File No: SF17/1975
Ref No: DOC17/151418

Request for comment on exhibition of Environmental Impact Statement for Stage 2 Design and Construction for the Western Sydney Stadium (SSD 8175)

18 April 2017

Figure 4 – Additional Heritage (& Urban) Views

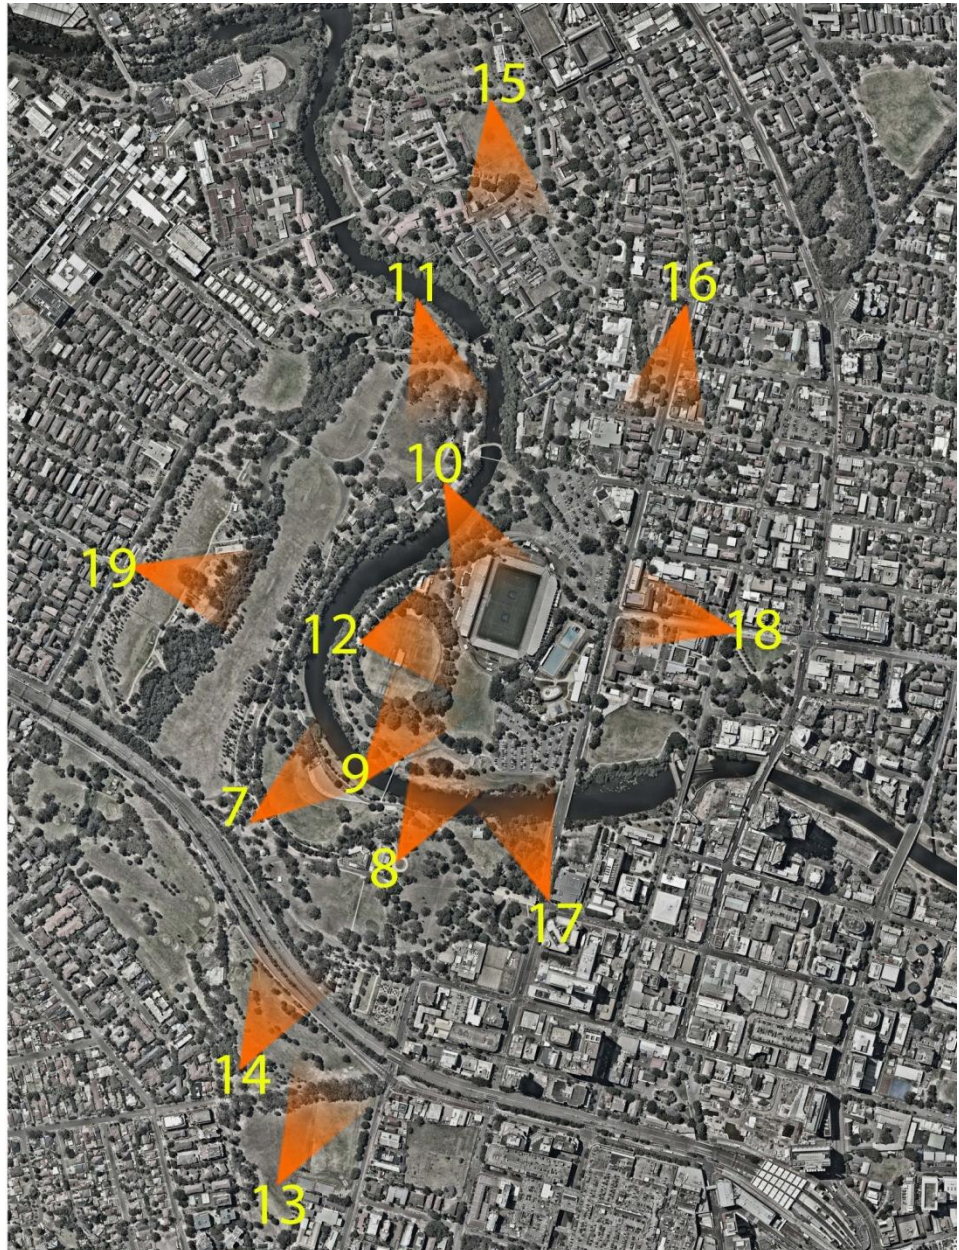
The Stage 1 Visual Impact Assessment (VIA) provided views of the envelope of the new stadium from a number of vantage points, including those identified in the Conservation Agreement. The Stage 2 VIA also includes the Conservation Agreement views. However interprets their exact locations differently to the Stage 1 VIA. The images are also much smaller, which makes it difficult to compare how the potential impact to views has been minimised through the detailed design. At this stage not enough information has been provided to adequately assess the visual impacts of the stadium.

It is recommended that the Stage 2 VIA is revised to provide larger, more detailed images depicting the same Conservation Agreement views shown in the Stage 1 VIA. The VIA should also provide views from surrounding places of heritage significance where the new stadium would be a prominent new element; including views facing north along O'Connell Street showing the stadium in the context of Parramatta Park and Old Kings School, from Old Kings School facing west towards the new Stadium, and from the intersection of O'Connell Victoria Road, showing the video screen in the context of the streetscape.

- 2) The Visual Impact Assessment should be revised to provide larger, more detailed images depicting the same Conservation Agreement views shown in the Stage 1 VIA and provided to the Heritage Council for comment. The VIA should also provide views from surrounding places of heritage significance where the new stadium would be a prominent new element; including views facing north along O'Connell Street showing the stadium in the context of Parramatta Park and Old Kings School, from Old Kings School facing west towards the new Stadium, and from the intersection of O'Connell Victoria Road, showing the illuminated signage in the context of the streetscape.
